17th March 2026

Application No: K/3/26/PD
Site Address: Potato Barn Kingston Lane East Preston BN16 1RS
Description of works: Prior approval under Schedule 2, Part 3, Class Q for the conversion of existing barn into 3 No. dwellings.

Thank you for your internet representation made on 16th March 2026 which has been recorded as an objection with the comments as follows:

**Proposed Site Plan
(Current application K/3/26/PD)**

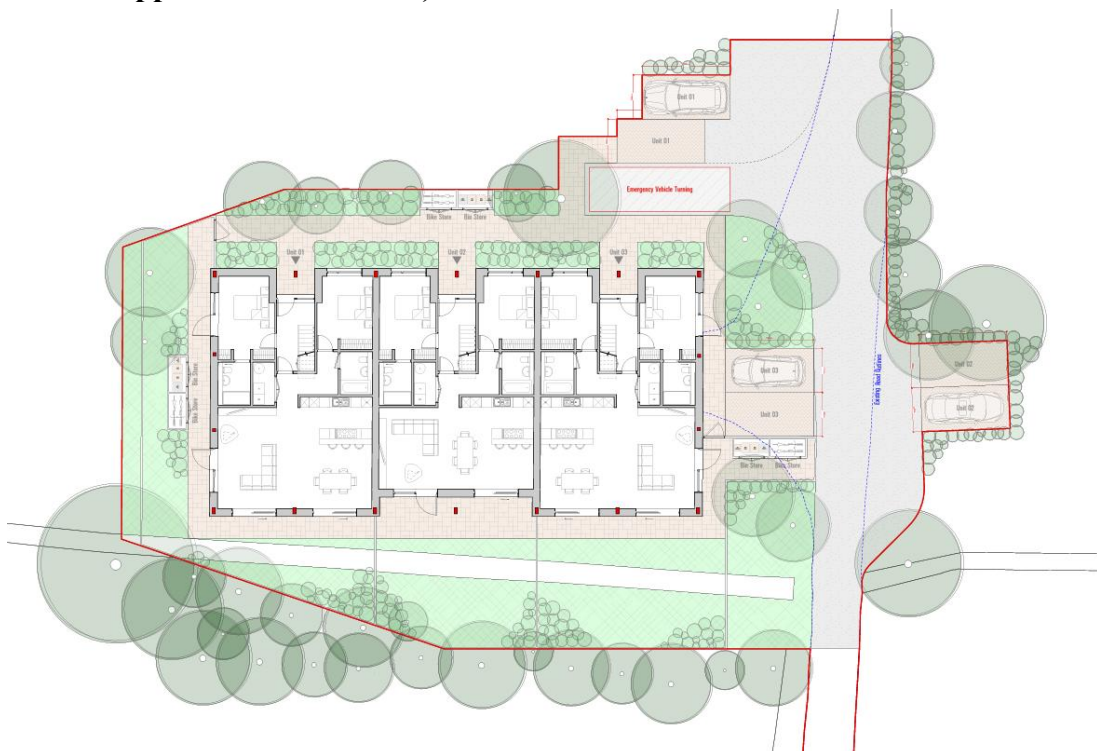
150% Increase in Traffic: While the lane serves two existing dwellings, adding three further units (indicated by six parking bays) represents a 150% increase in residential volume. This is fundamentally different from occasional agricultural traffic.

Structural/Logistical Limits: The unmade surface is not designed for heavy construction or increased residential traffic. The 90-degree bends are at capacity; additional households will lead to hazardous reversing maneuvers onto the main highway or into pedestrians.
